Subject: 3055 Richmond Holding Inc. – 3055 Richmond Road – Site Plan Control Application 7th Submission - City File No. D07-12-22-0147

On behalf of 3055 Richmond Holding Inc. (the “Client”), please find enclosed, the seventh submission for the Site Plan Control (File No. D07-12-22-0147) Application, located at 3055 Richmond Road, in the City of Ottawa. The enclosed resubmission package addresses the City’s comments received on October 30, 2025.

2022-05 3055 RICHMOND ROAD 2022-01-05.DWG ISSUED ON January 5, 2026 3:15:13 PM

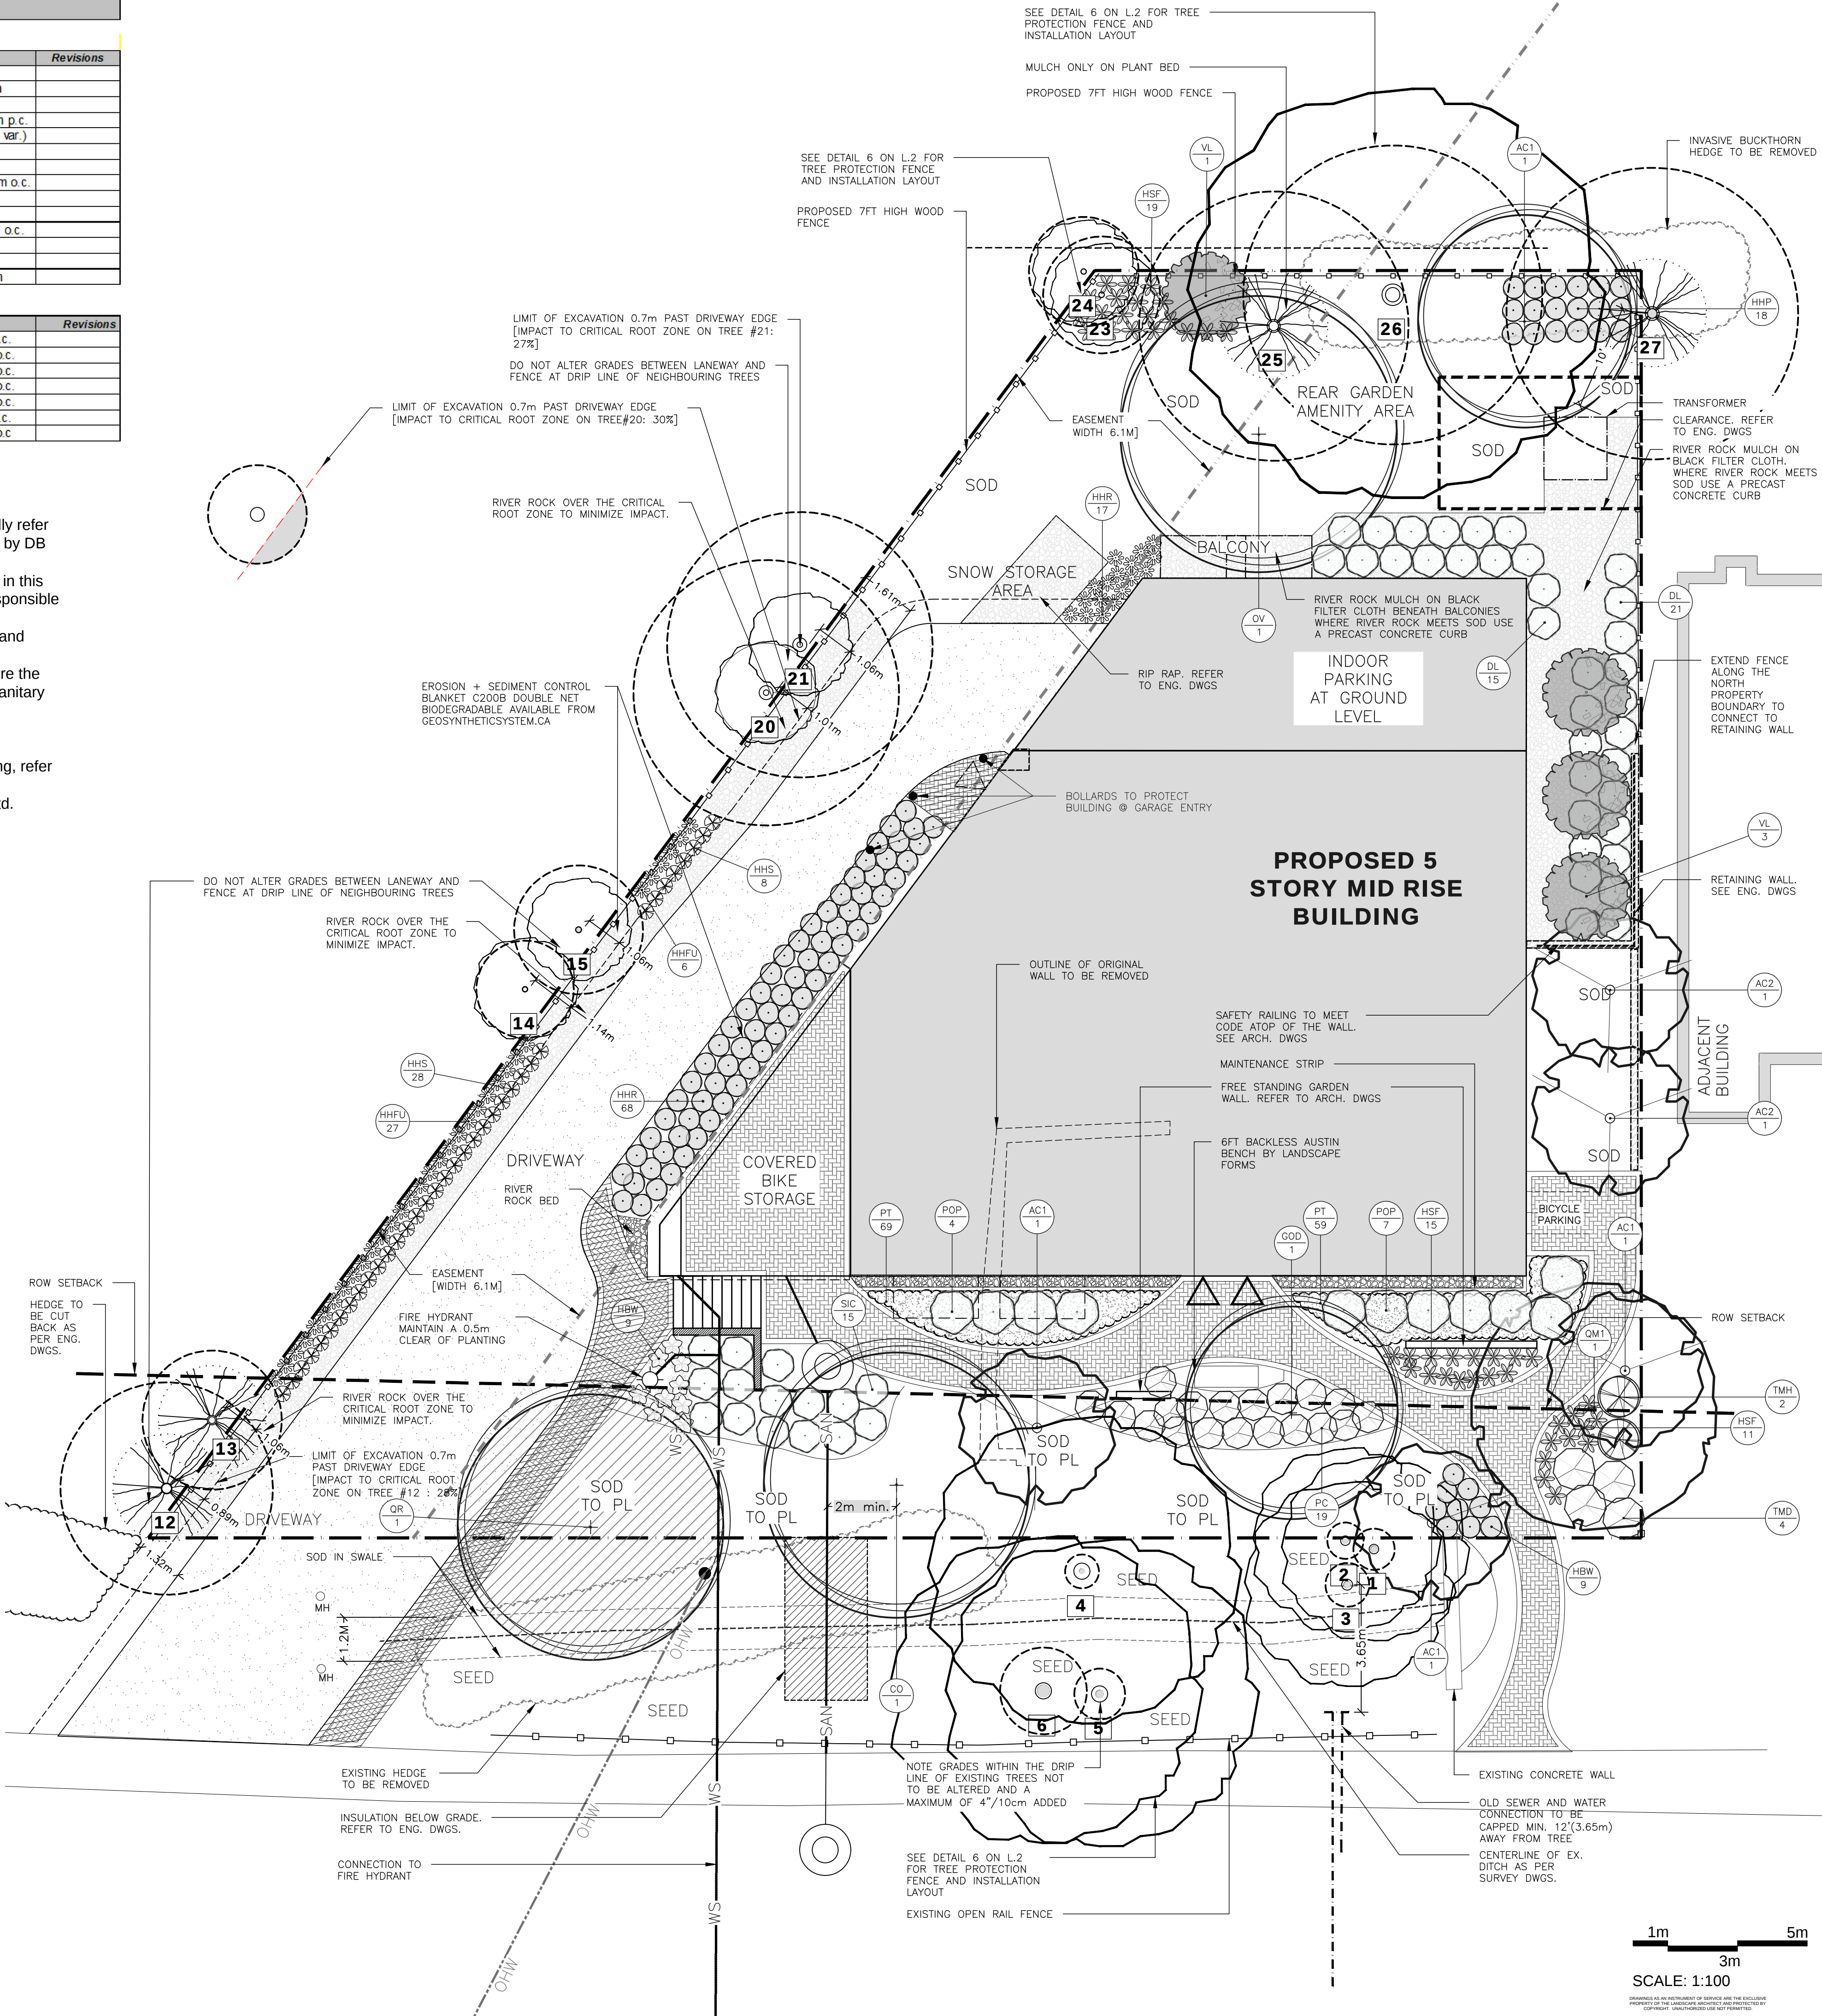
8. **Is there an opportunity to replace some of the river rock along the east side of the property, between the proposed trees and transformer, with additional trees or other plantings?**

10. Remove proposed landscape mulch in the ROW and replace with sod.

11. Please clarify what the dashed lines in this area indicate:

12. 7th Submission Comment: The plan(s) must be revised to address section 71 of the Water By-Law below. The applicant has the choice to either remove the landscaping features around the private hydrant or move the fire hydrant to comply.

Tight space limitations, the neighbour's retaining wall and minimal light make it difficult for any small tree to grow other than Nannyberry which is a large shrub. It does well in shade and we have added three to the plan.

Noted.

The dashed line refers to insulation below grade as per the engineering drawings. An additional note has been added to the drawing.

The moveable specimen boulders has been relocated just outside the easement line. A note has been added on the planting clearance to the hydrant in the revised landscape Plan.
